ACCESS REPORT

BIOLOGICAL SCIENCES PROJECT

BOTANY STREET, KENSINGTON UNIVERSITY OF NSW

SSD 6674 SUBMISSION

Drawing number
A2203

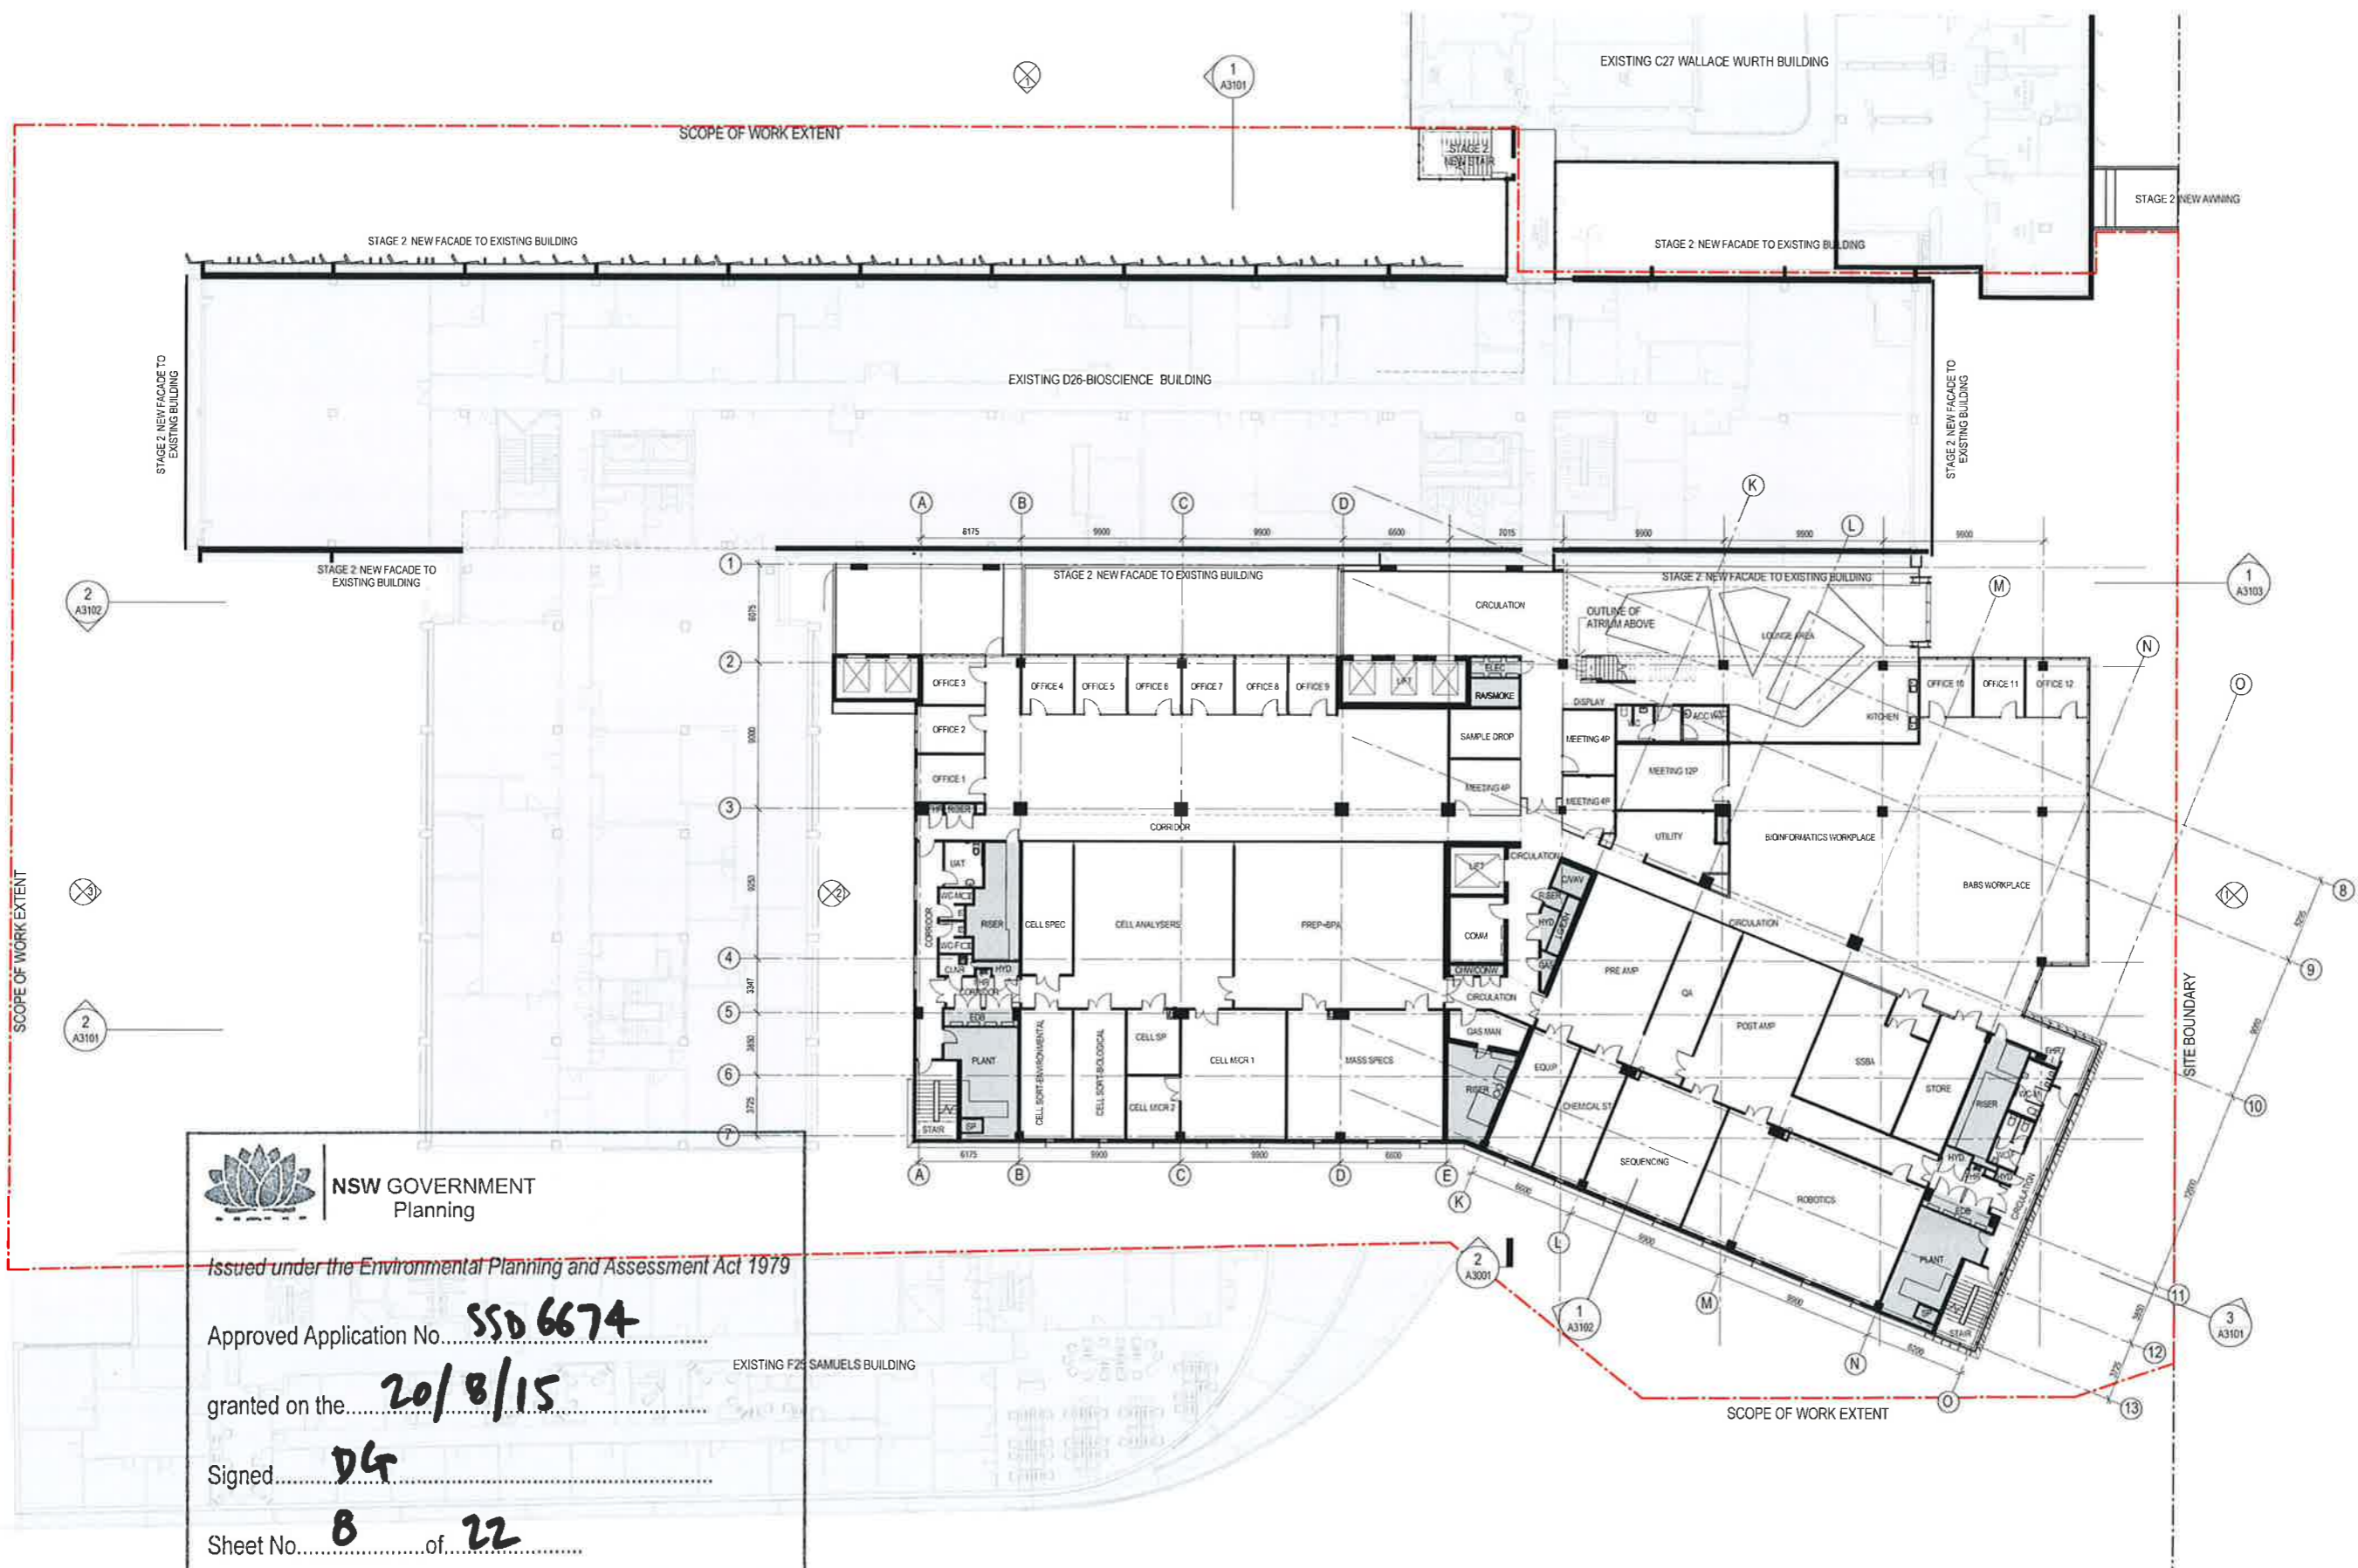
| <p>24. The central lift landing provides ample width while the central access corridors propose varying widths of 3000mm minimum leading to doorways to access several teaching labs, a workplace office, sanitary facilities and corridor link to the larger goods/passenger lift lobby and prep areas to readily comply with ASI428.1, Part D3.3 of the BCA and DDA Access Code in terms of doorway circulation spaces, Turning and Passing areas.</p> | <p>YES</p> |

| BCA / DDA Access Code Review | Complies |
|---|------------------------|
| <p>32. Double doorways to the larger goods/passenger lift lobby and prep areas and single doors to various offices, meeting rooms and sanitary facilities provide appropriate doorway circulation spaces to comply with ASI428.1, Part D3.3 of the BCA and DDA Access Code.</p> | YES |
| <p>34. The western group of sanitary facilities will provide a unisex accessible toilet in accordance with ASI428.1 to satisfy Parts D3.3 and F2.4 of the BCA and DDA Access Code, which will be confirmed at a future construction documentation stage.</p> | YES at CC stage |
| <p>35. Ambulant accessible male and female toilet cubicles are required in accordance with ASI428.1 to comply with Part F2.4 of the BCA and DDA Access Code.</p> | YES at CC stage |

| BCA / DDA Access Code Review | Complies |
|--|---|
| <p>49. Level I provides an area designated for sanitary facilities which will require detailing of a unisex wheelchair accessible toilet, male and female ambulant accessible cubicles.</p> |  <p>YES</p> |
